## Winchester City Council

### Summary of comments made at Hearings held from 9 December through to 15 December 2020

**1 Converter Station Parameter Plan Options B(i) and B (ii)**  
1 : 2500

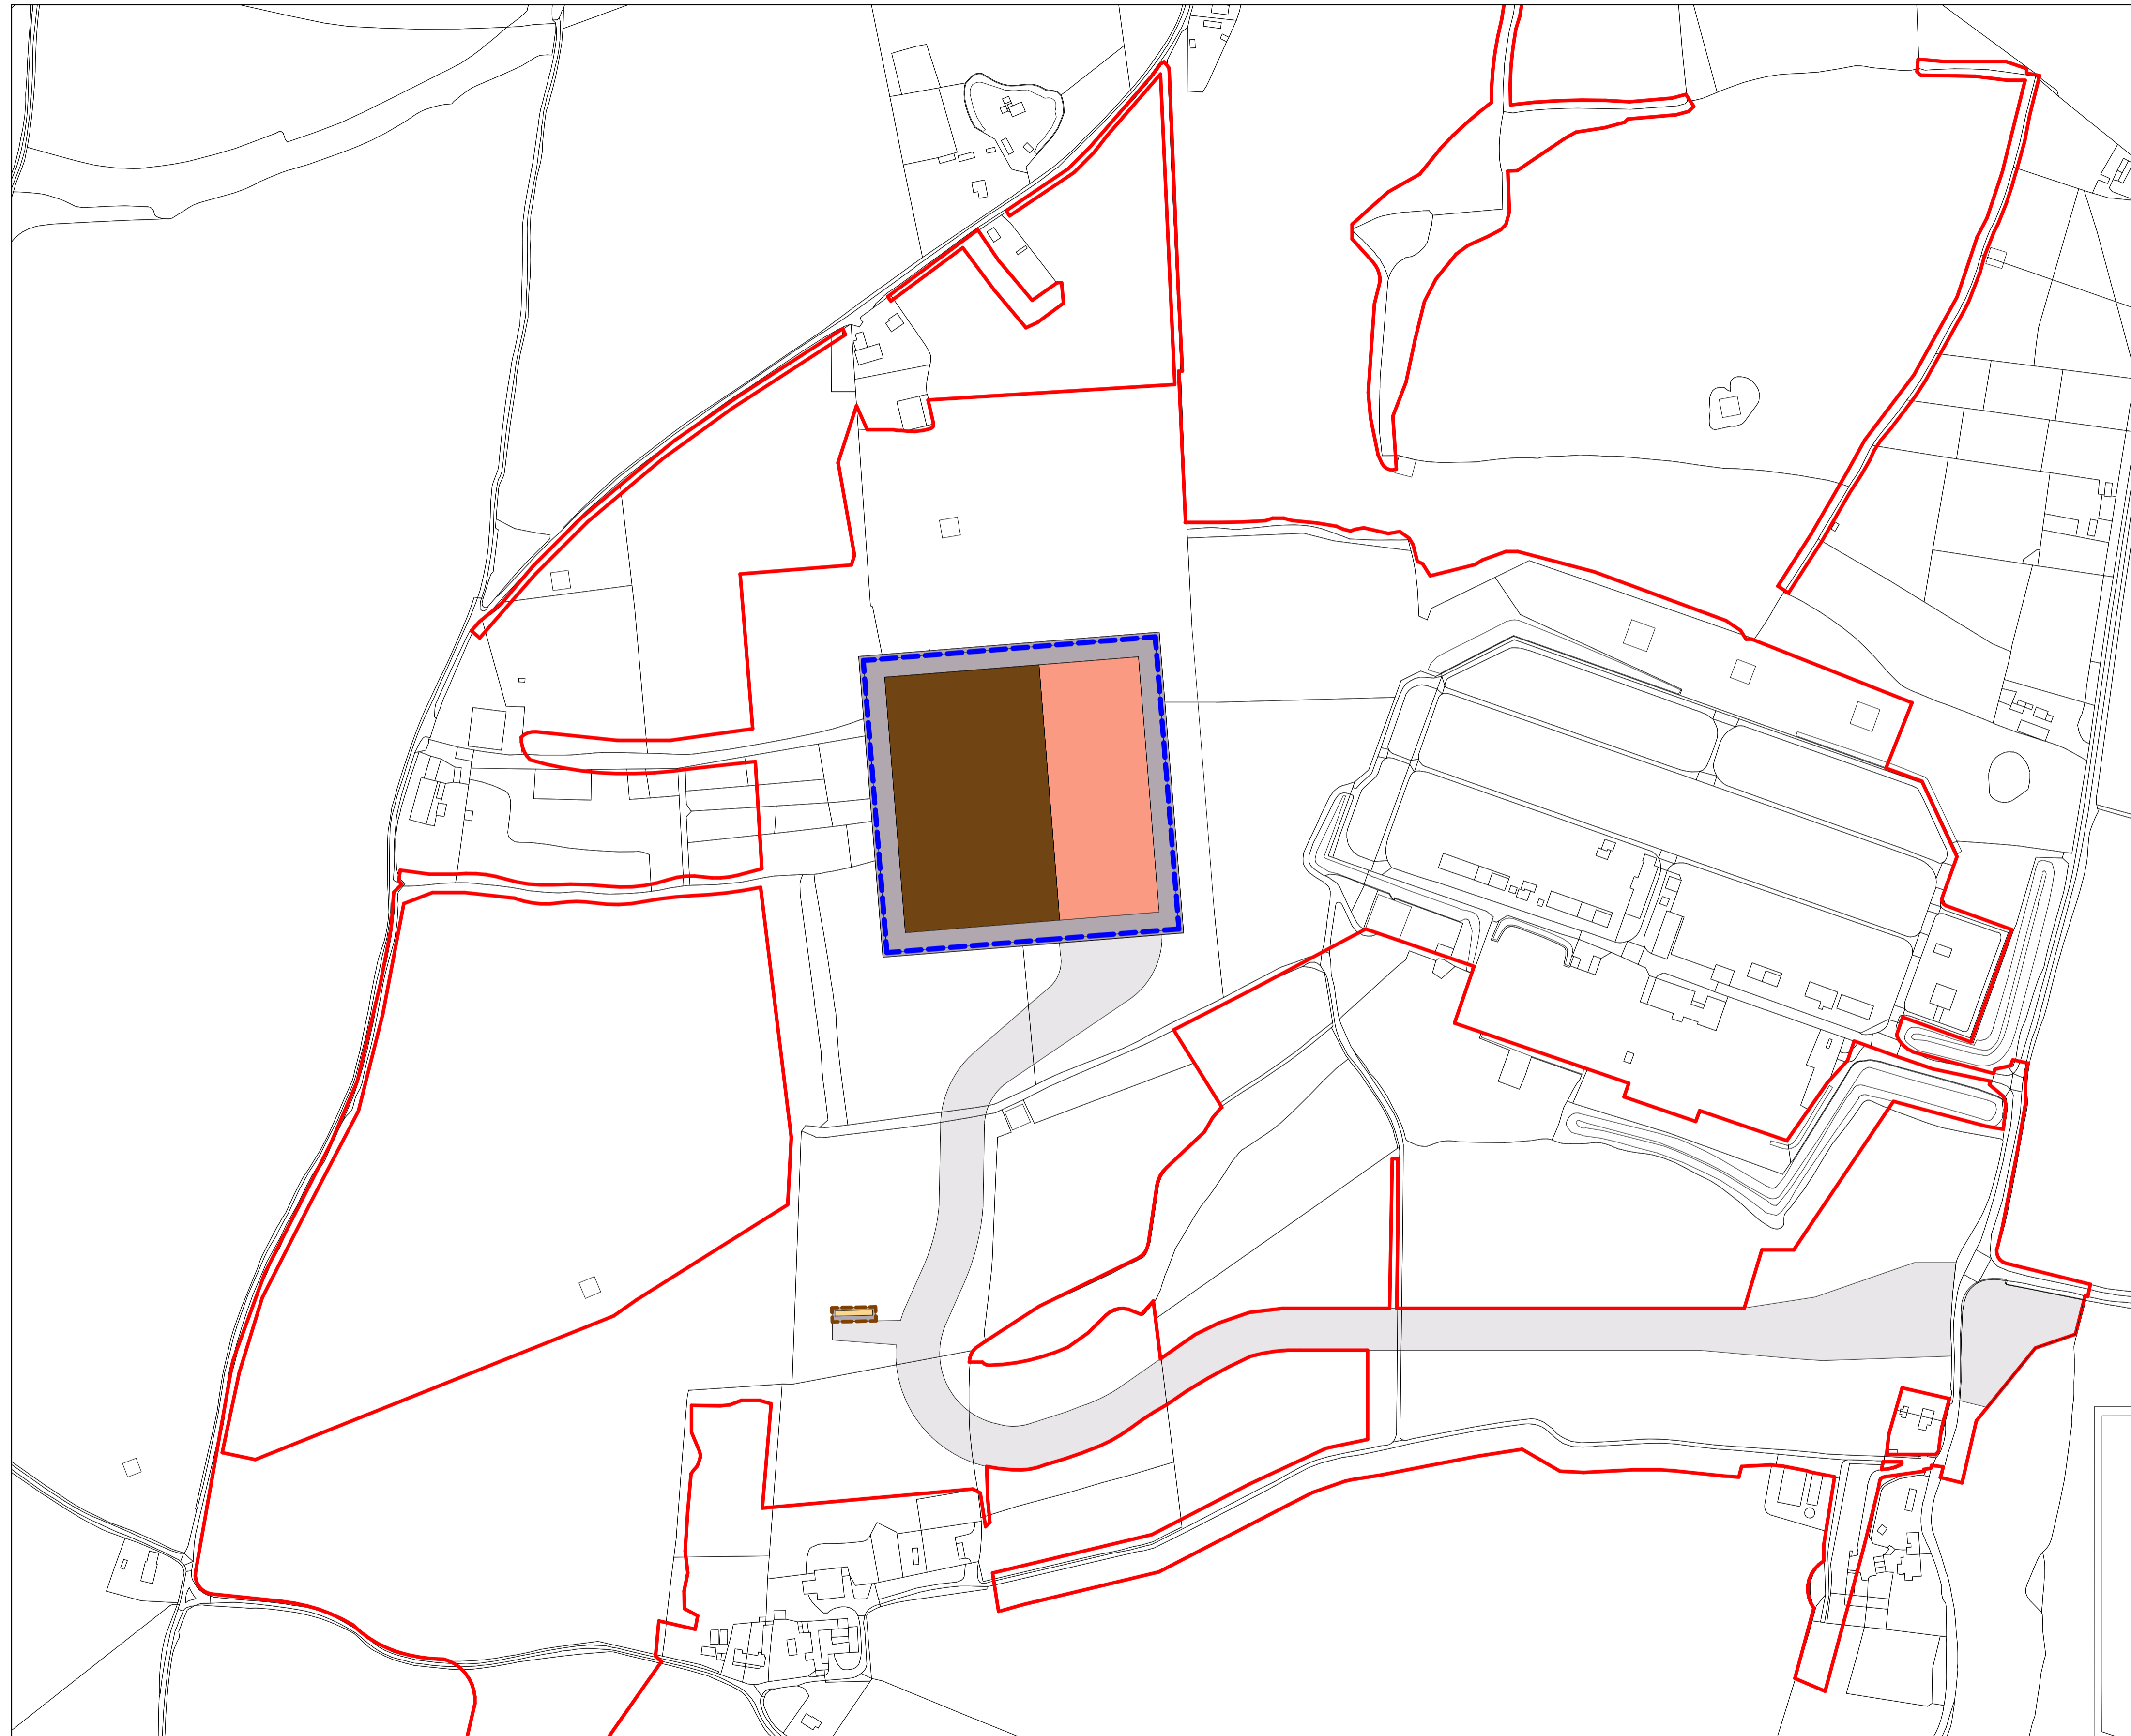
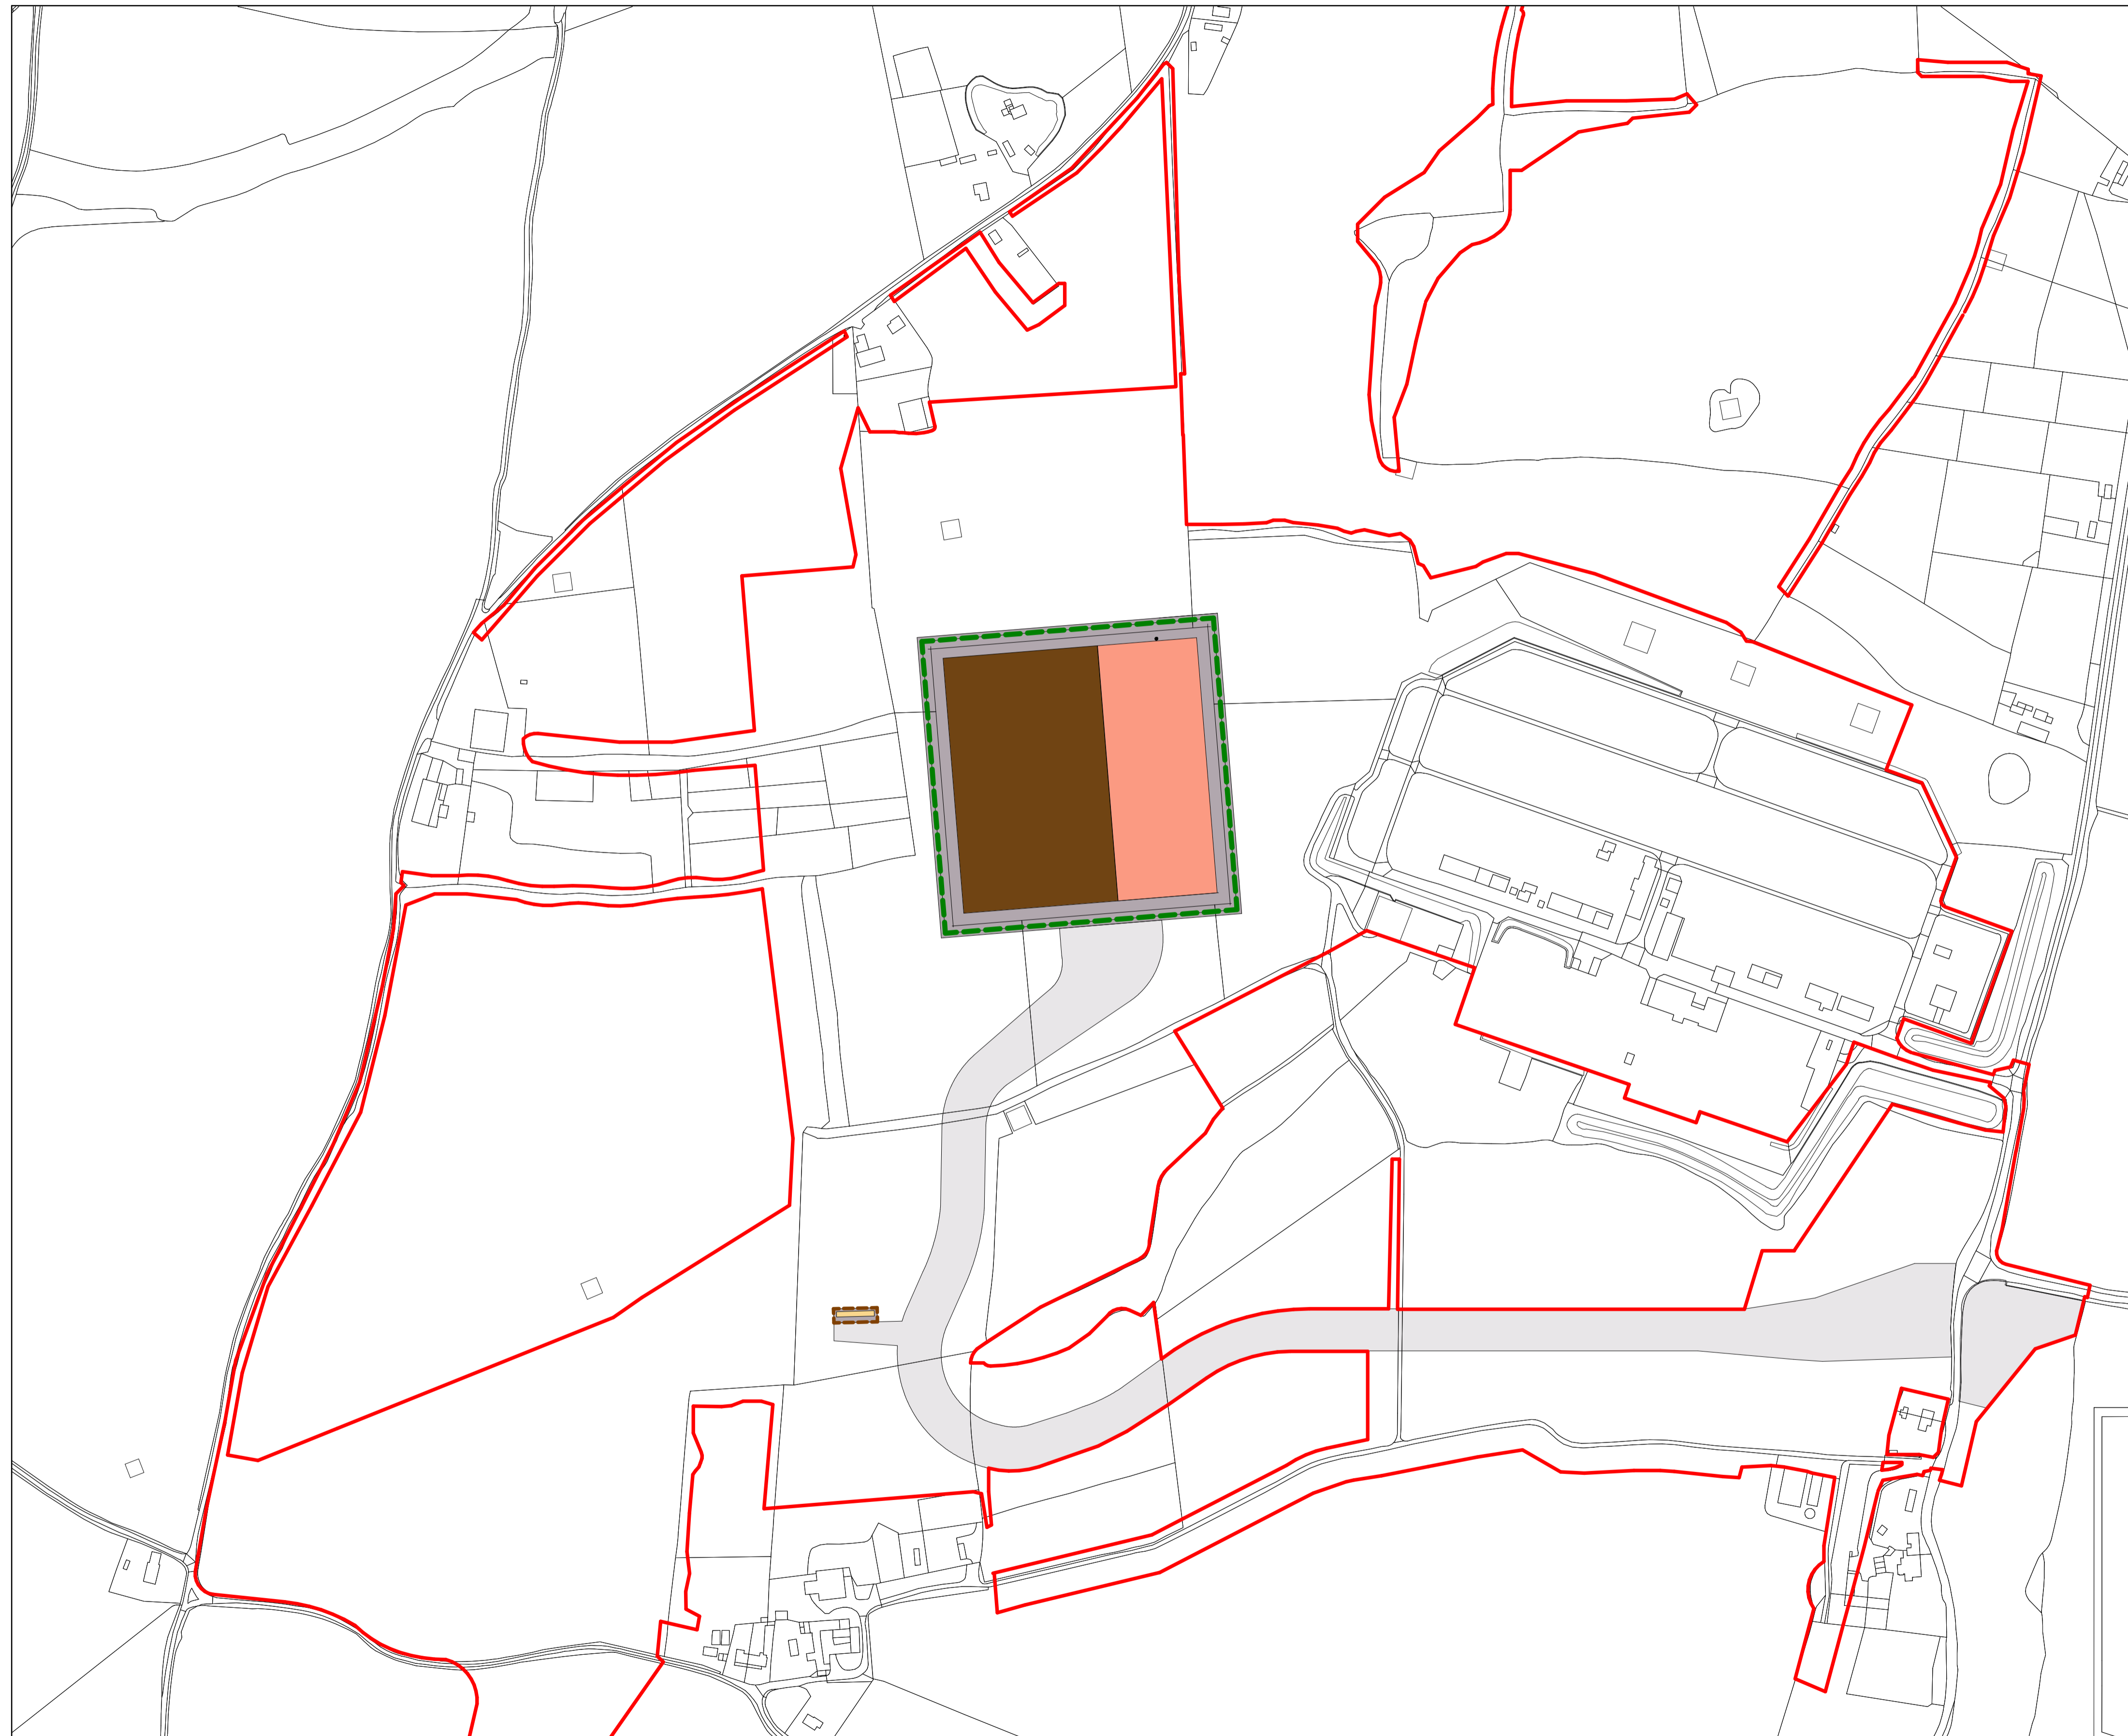
Winchester City Council notes the applicants explanation relating to the variation in the height of the equipment which is driving the request to maintain some flexibility in the height of the proposed converter station building. However, the Council notes the reference in the applicants explanation that the design of the roof will also play a role in the overall height of the building. If the choice to be made by the contractor comes down to one of a lower roof but at a higher cost, what weight is going to be given to minimising landscape impact in that decision process? How is the overall desire to bear down on height to be embedded in the final decision on building design?
